Our ref: Trinity Grammar School Redevelopment – Modification 2 (SSD-10371-Mod-2)

8 April 2022

Subject: Request for Additional Information

Source: Arcadia Landscape Architecture, Drawing No. 200, October 2020, Issue C.

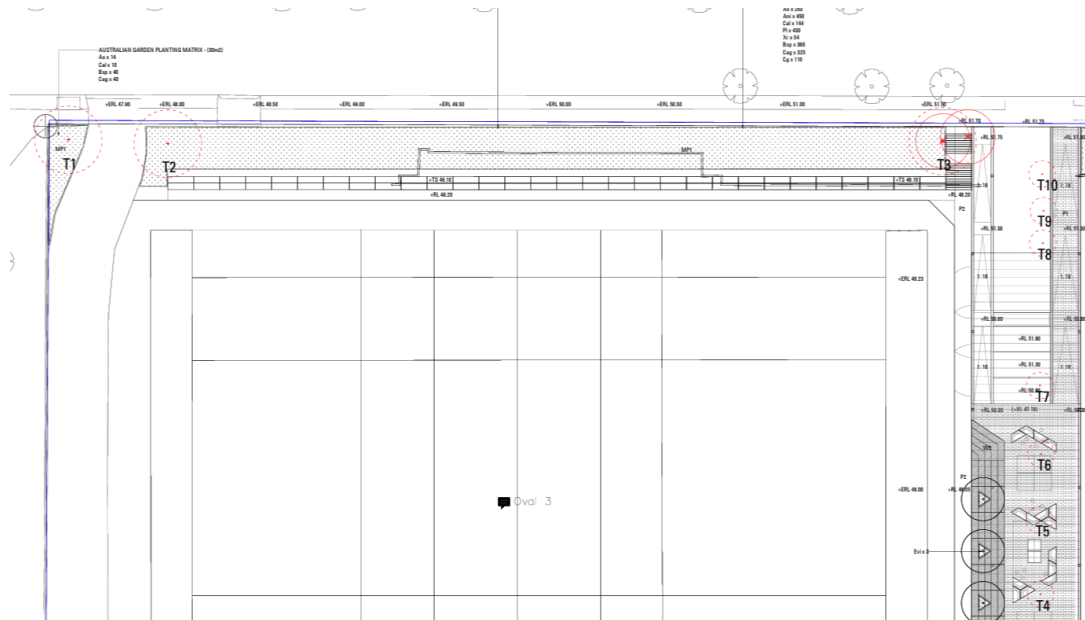
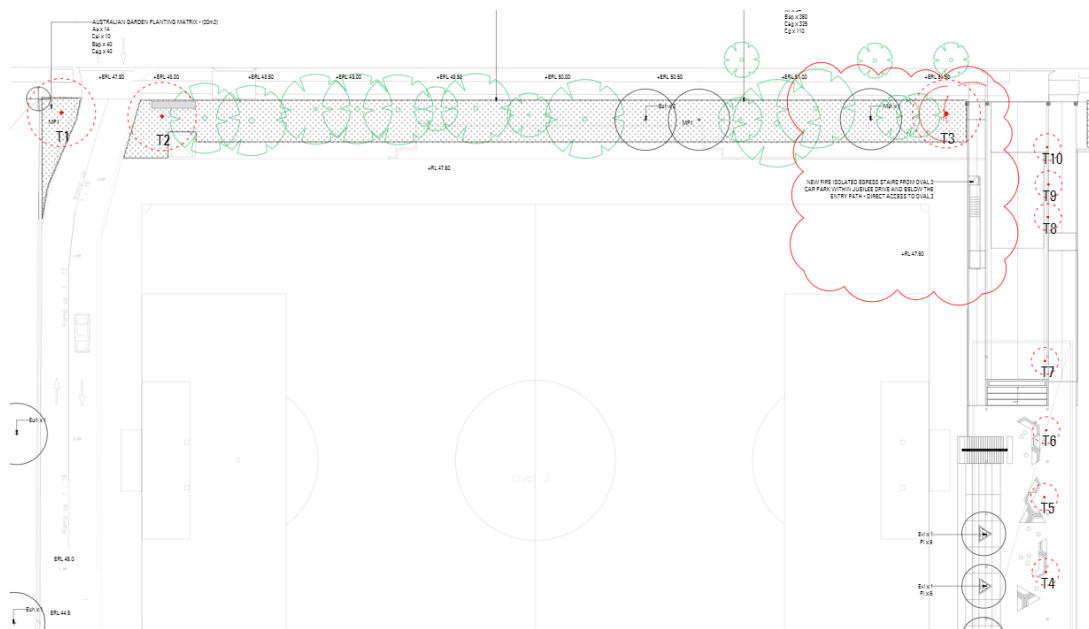
- (b) The Landscape Master Plan (sheet 100) does not accurately detail the location of trees at Lot 7020 DP 93165, when compared to the Landscape Plan Sheet 200.

Source: Arcadia Landscape Architecture, Drawing No. 207, October 2020, Issue C.

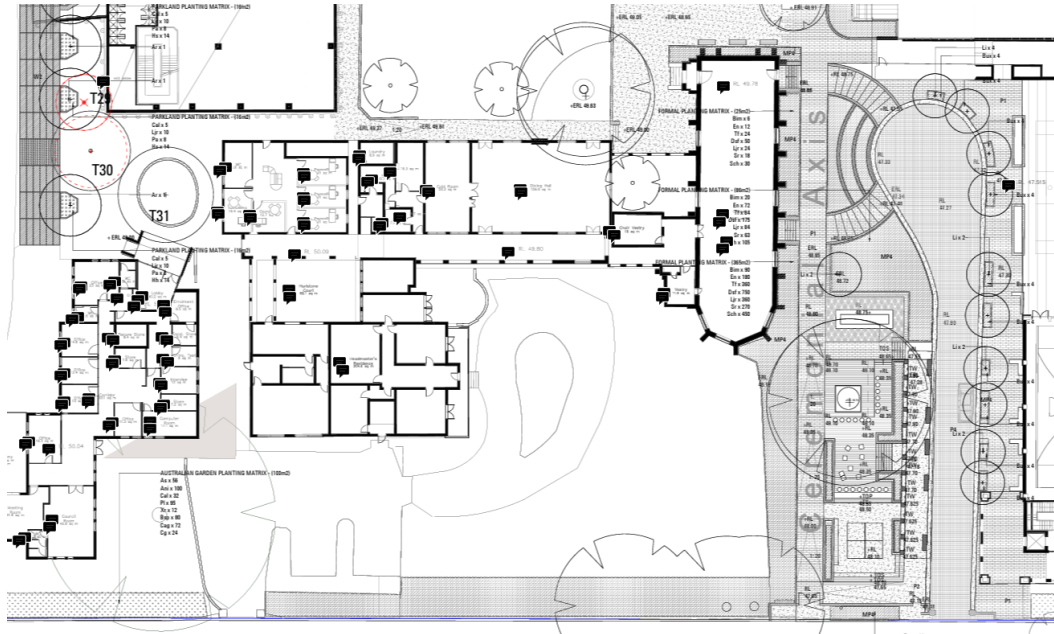
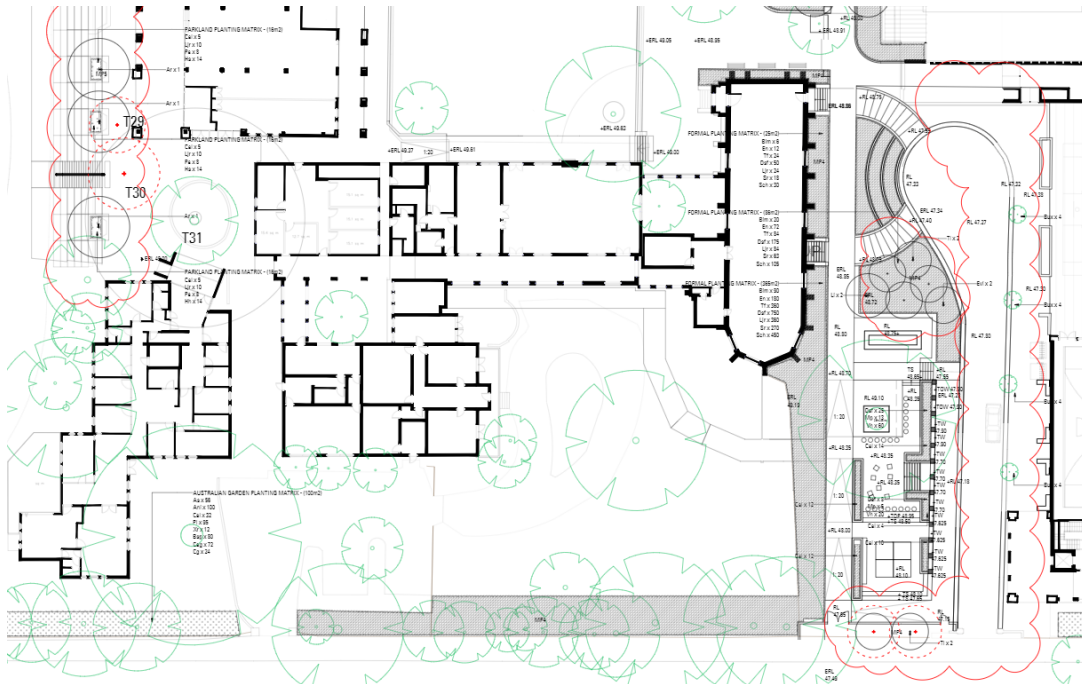
- (h) The Landscape Plan (sheet 207) identifies that the four Japanese Box trees are proposed to be removed, under this modification application. This is conflicting with the approved deferred commencement plans, as these four trees were shown to be retained. The annotation on the plans submitted on 25 March 2022, being “out of scope of development”, provides unclear justification as to why these trees are now sought to be removed. The Department considers that these trees should be retained. You are requested to amend the plans to reflect this.

PLANTING SCHEDULE

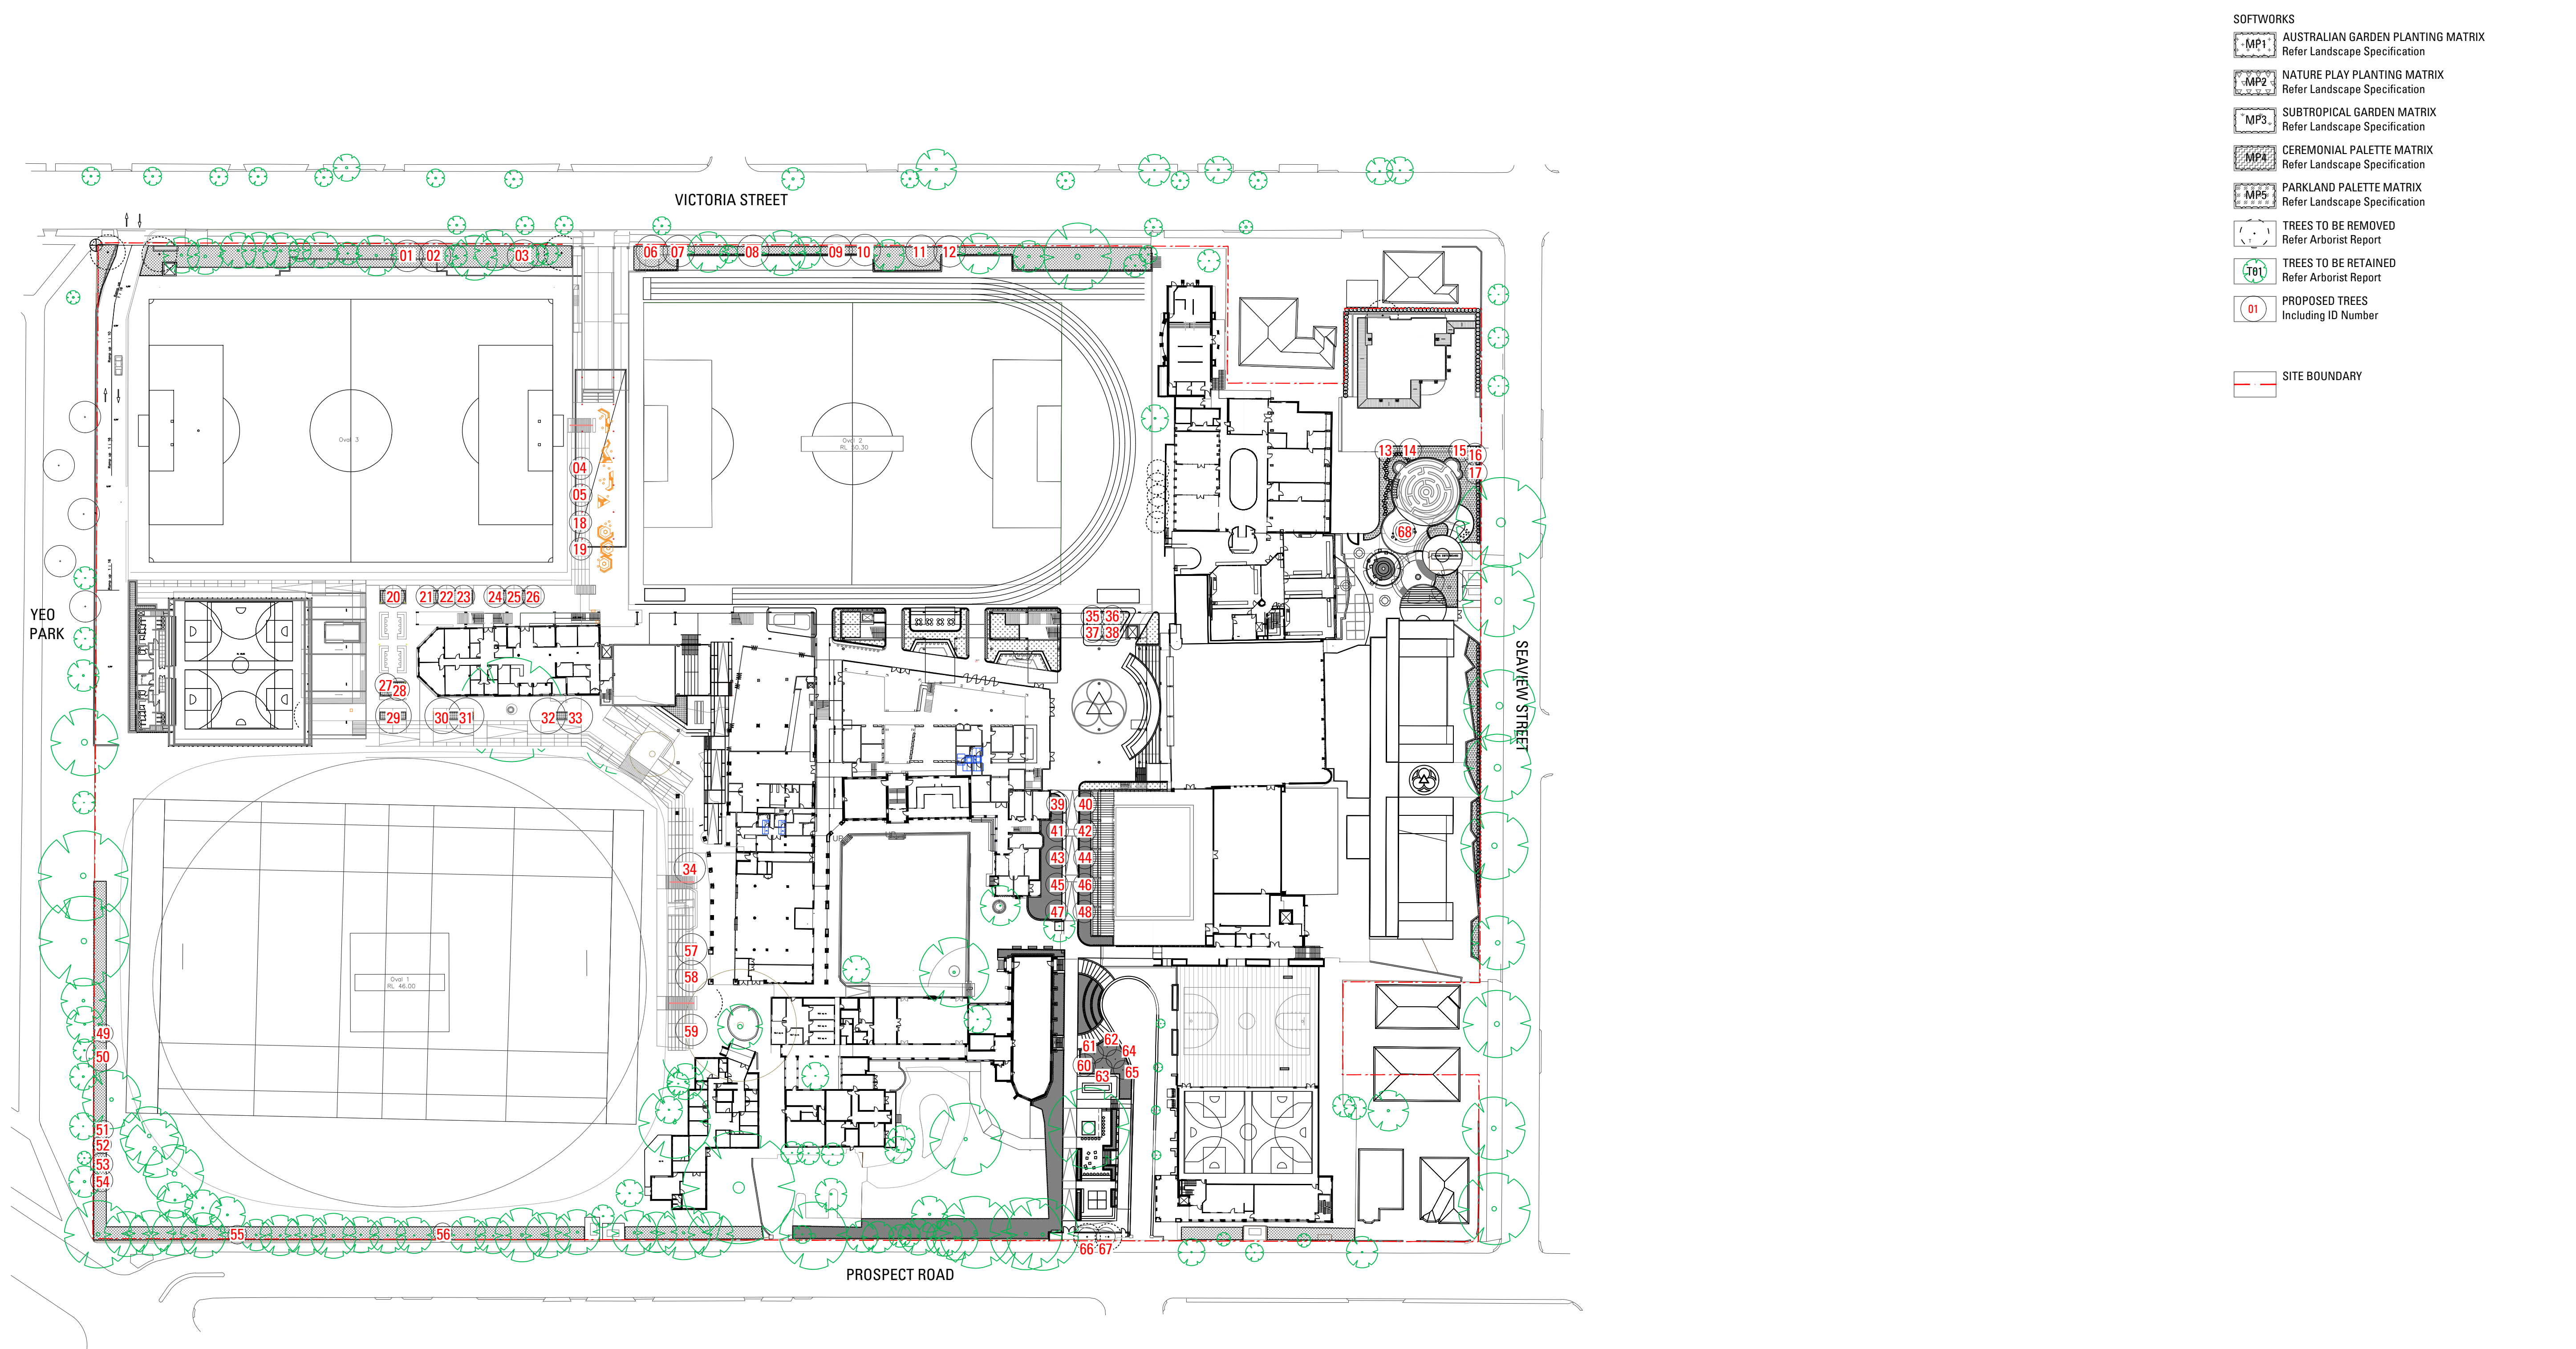
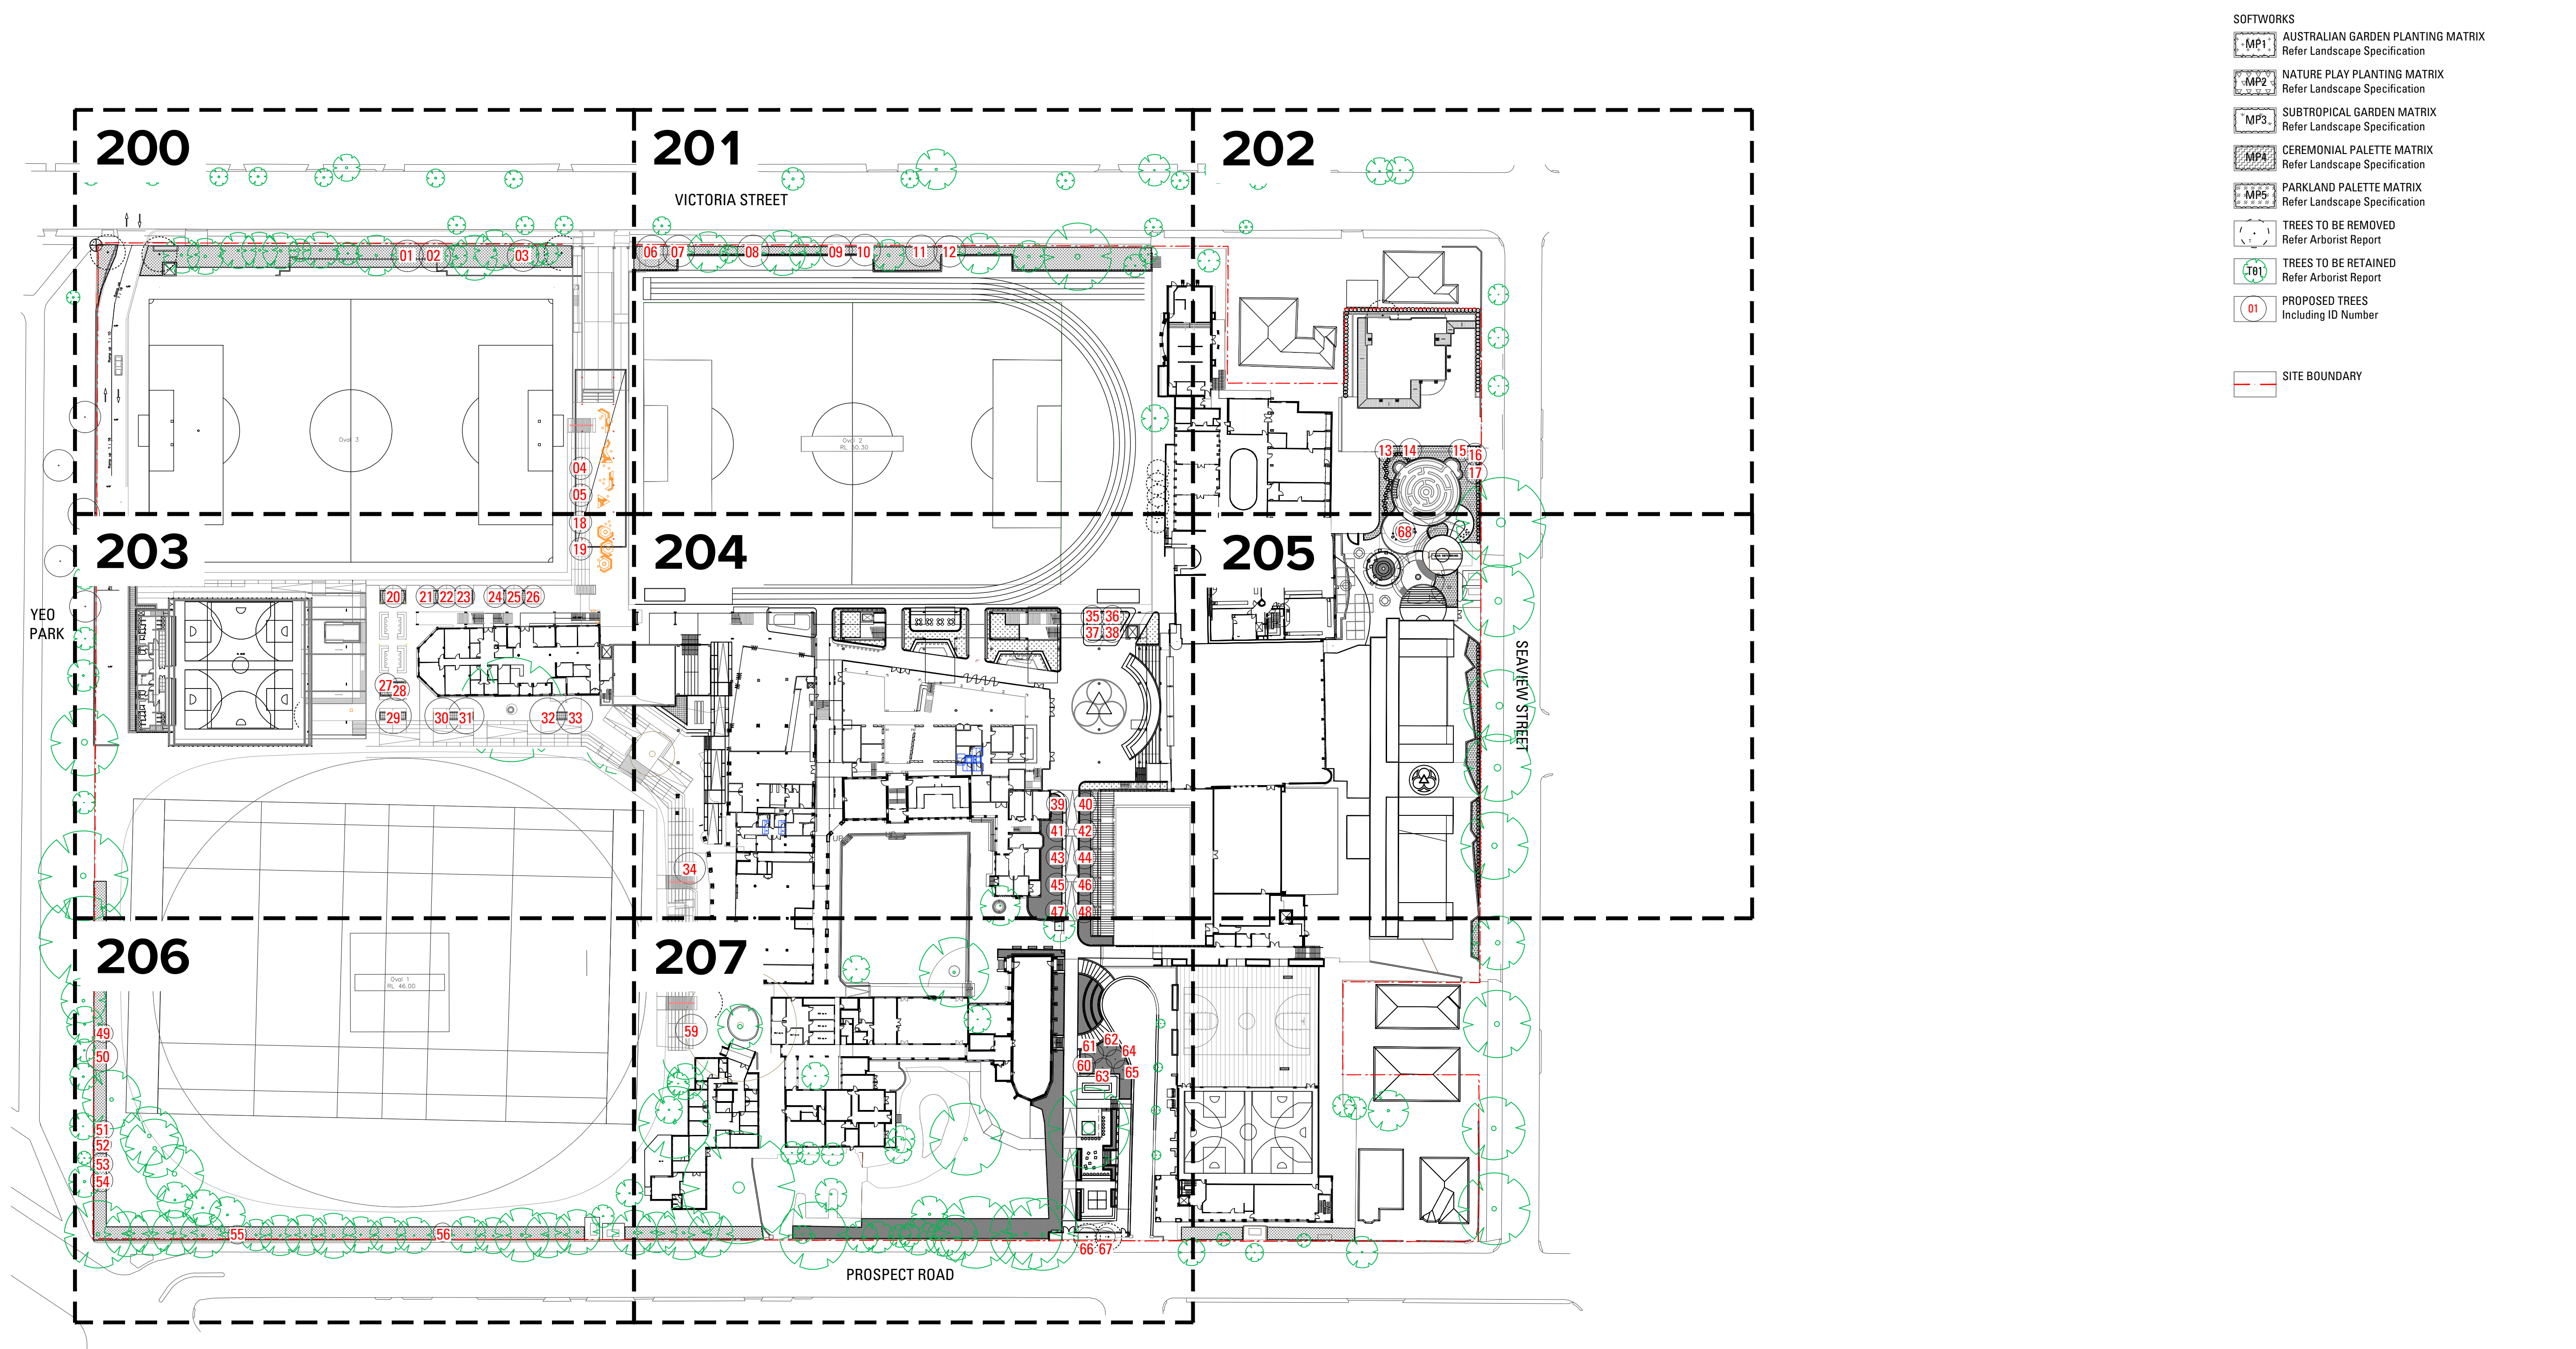
- (d) All proposed trees on the landscape plans should be number identified. The proposed planting schedule table (sheet 100) should include the tree identification numbers.
